2021/0807

Erection of two storey side and rear extension and single storey rear extension to dwelling

6 Mellwood Grove, Hemingfield, Barnsley, S73 0PW

SIDE ELEVATION

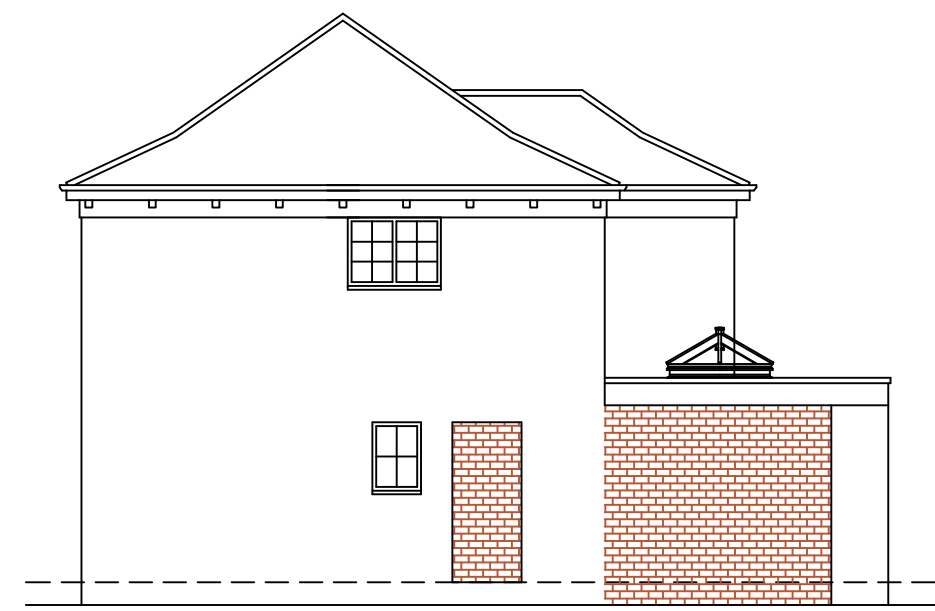
- Overlooking impact from proposed extension and balcony
- The proposed front extension of the garage does not follow the building line
- There is an error on the plans as the side elevation wall lengths do not match what is proposed on the first-floor plan and the site plan. This needs to be addressed on a new plan and resubmitted.

GROUND FLOOR PLAN

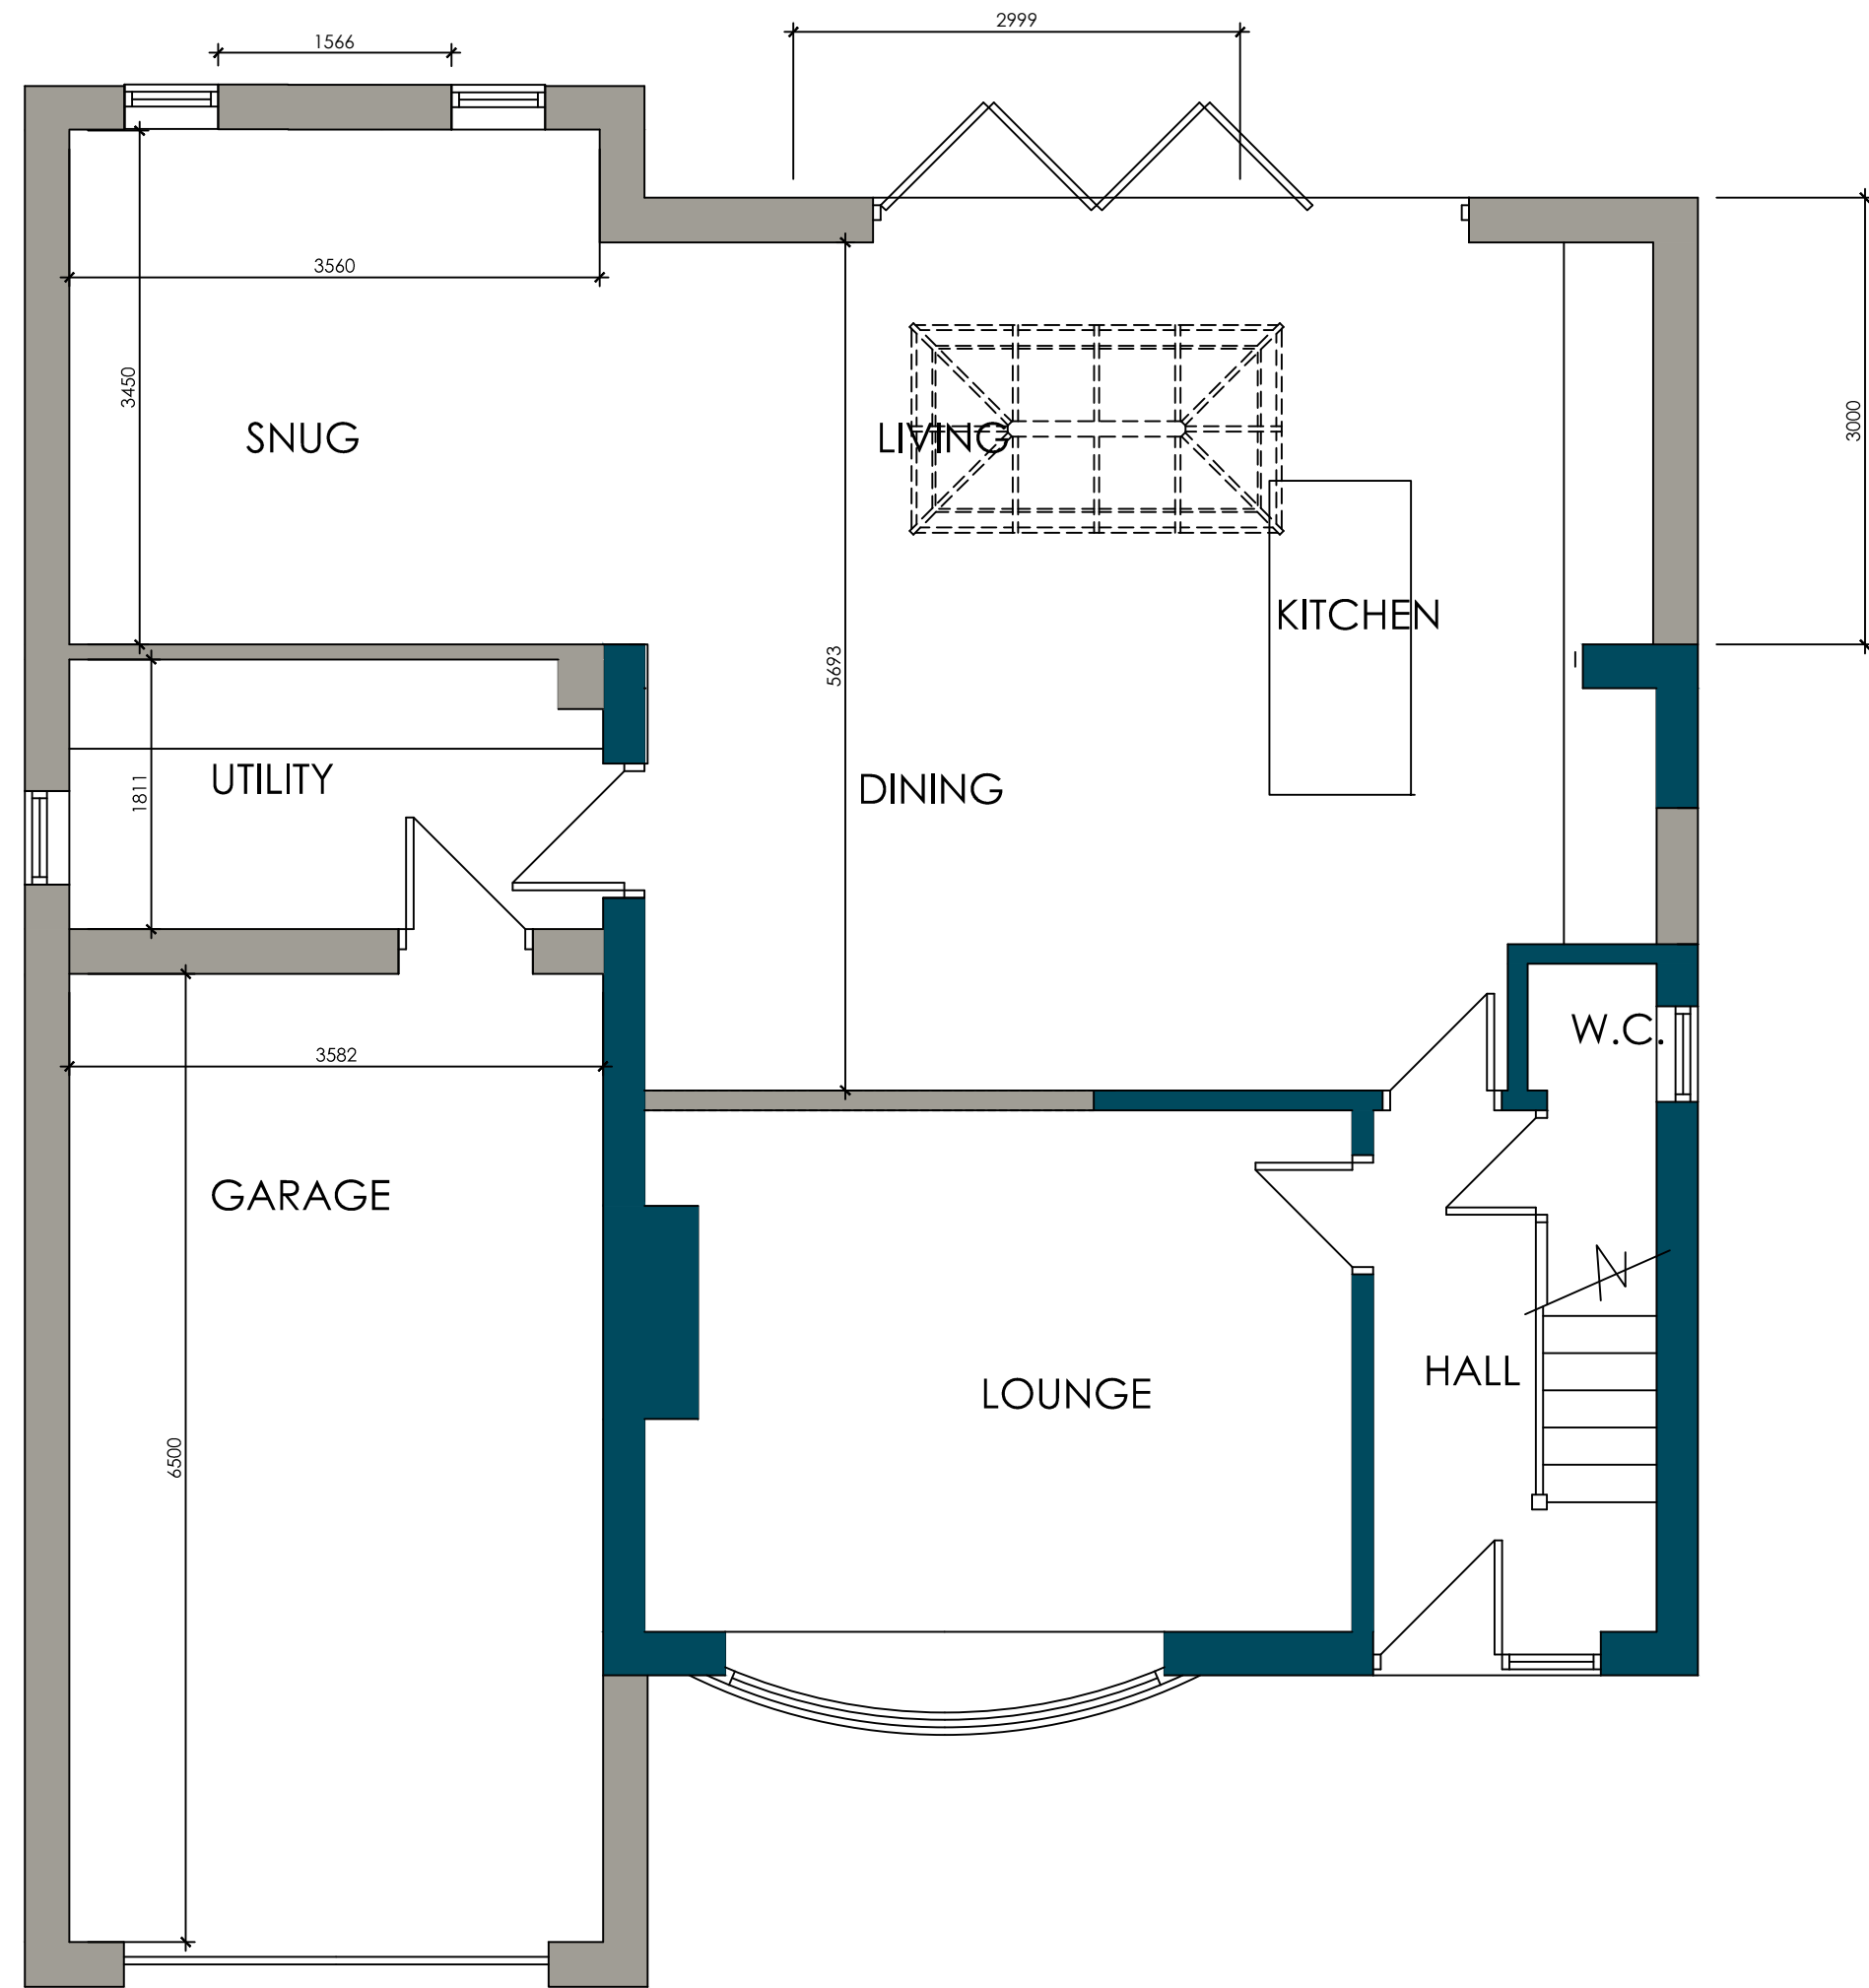
Concerns have been raised with regard to the front projecting garage, however the extension would be limited at 2.1m in projection and would not appear overly prominent or would significantly disrupt the building line. The SPD allows for small front extensions where they are not harmful to visual amenity, furthermore a similar front projecting element can be seen on the property to the west – number 4 and therefore a precedent has been set.

Whilst the proposal would result in the loss of part of the driveway to the property, there is sufficient parking for 2 cars in line with the SPD. The proposed integral garage would meet the size requirements in order to be counted as a parking space and the existing driveway has a length of approx. 8.6m which is sufficient.

FIRST FLOOR PLAN

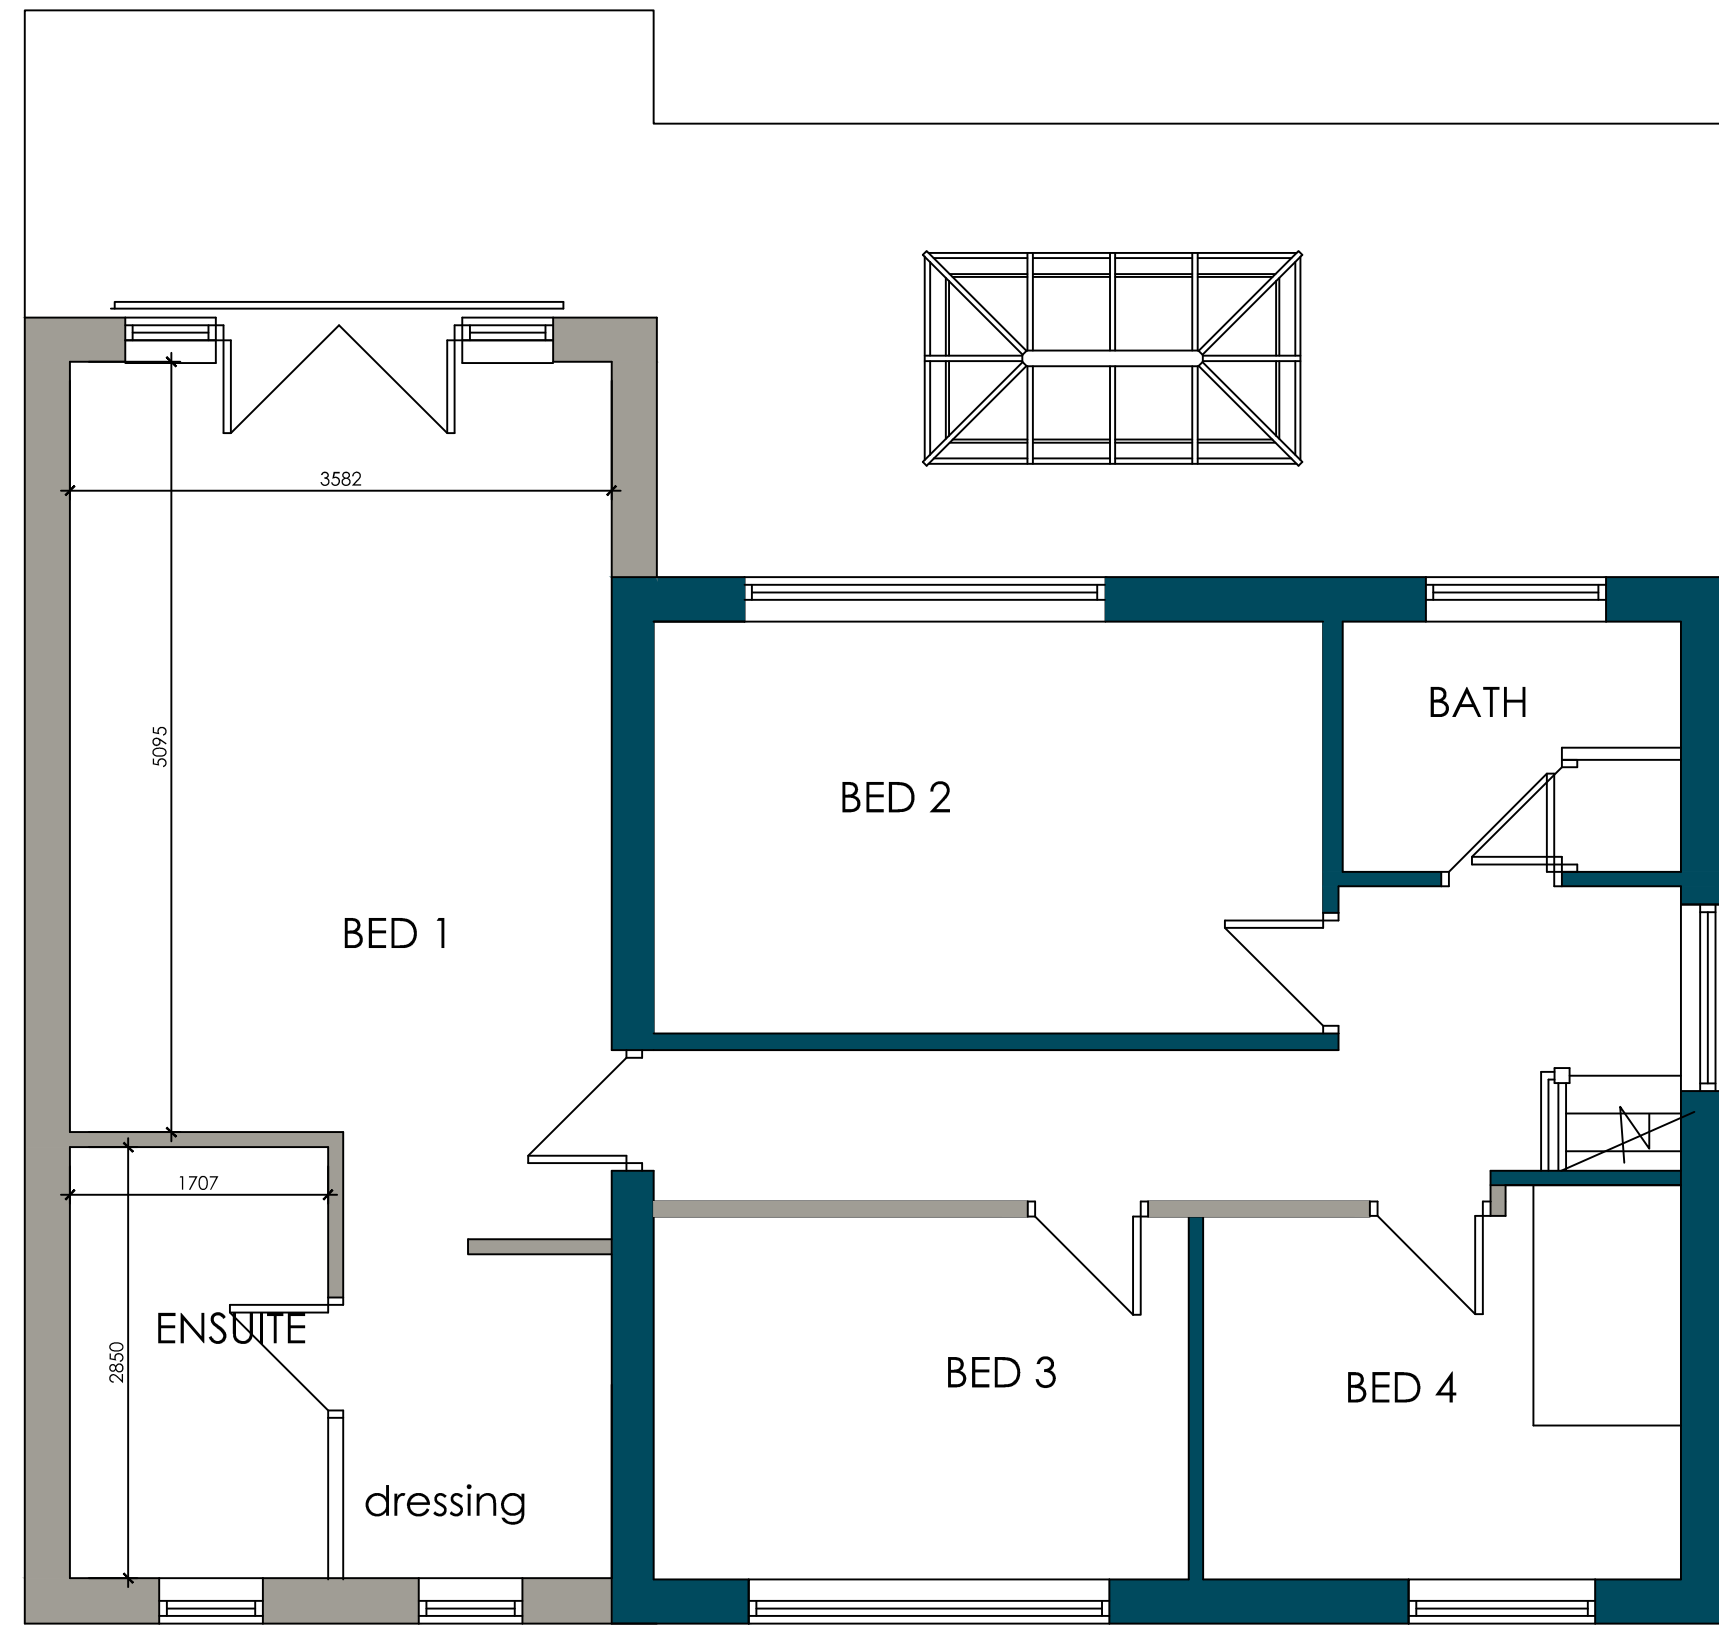
- The current rear extension configuration also directly looks over the existing patio at 8 Mellwood Grove. This would cause significant loss of privacy with no space for a privacy hedge

In terms of overlooking impact, there is one side window proposed to the ground floor utility, however this is not a habitable room and would not cause significant overlooking. Concerns have been raised by the occupants of number 8 with relation to potential overlooking from the proposed Juliet balcony window, however this is not a traditional balcony and would not cause any significant overlooking over and above a normal window in this location.

SITE PLAN
SCALE 1:500

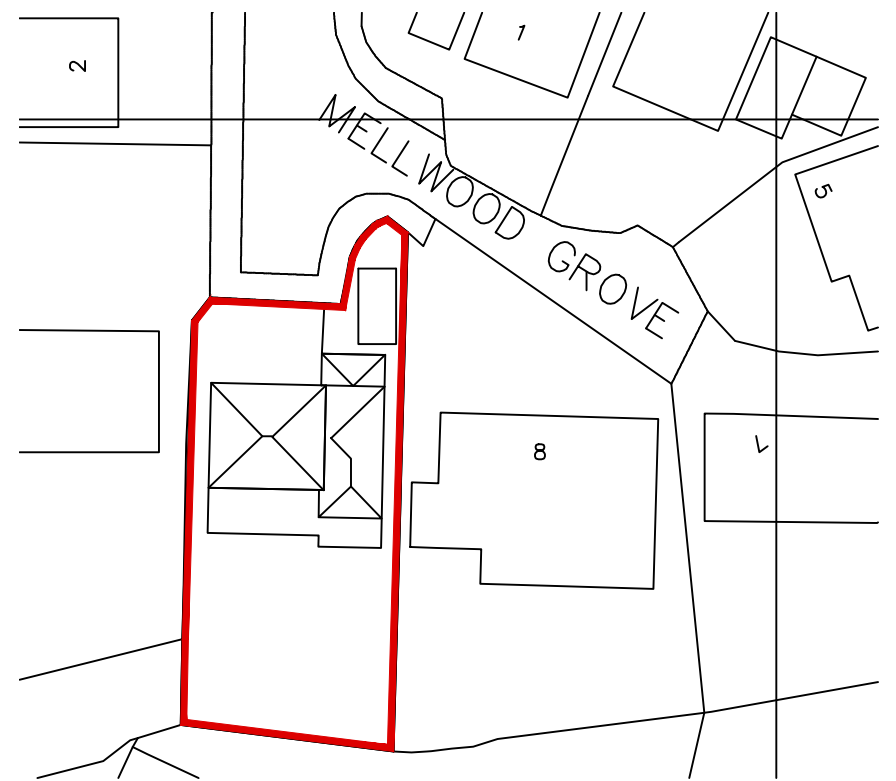
- The distance between the garage building line and the Boundary wall at 8 Mellwood Grove is currently 39 inches. Can there be clarification on what distance the developers wish to use between the boundary wall and the new development as it is not shown on the plans.

gap between the proposed extension and the side boundary with number 8 exceeds 1m in line with the guidance set within the SPD, so there should not be a significant loss of light or overbearing impact.
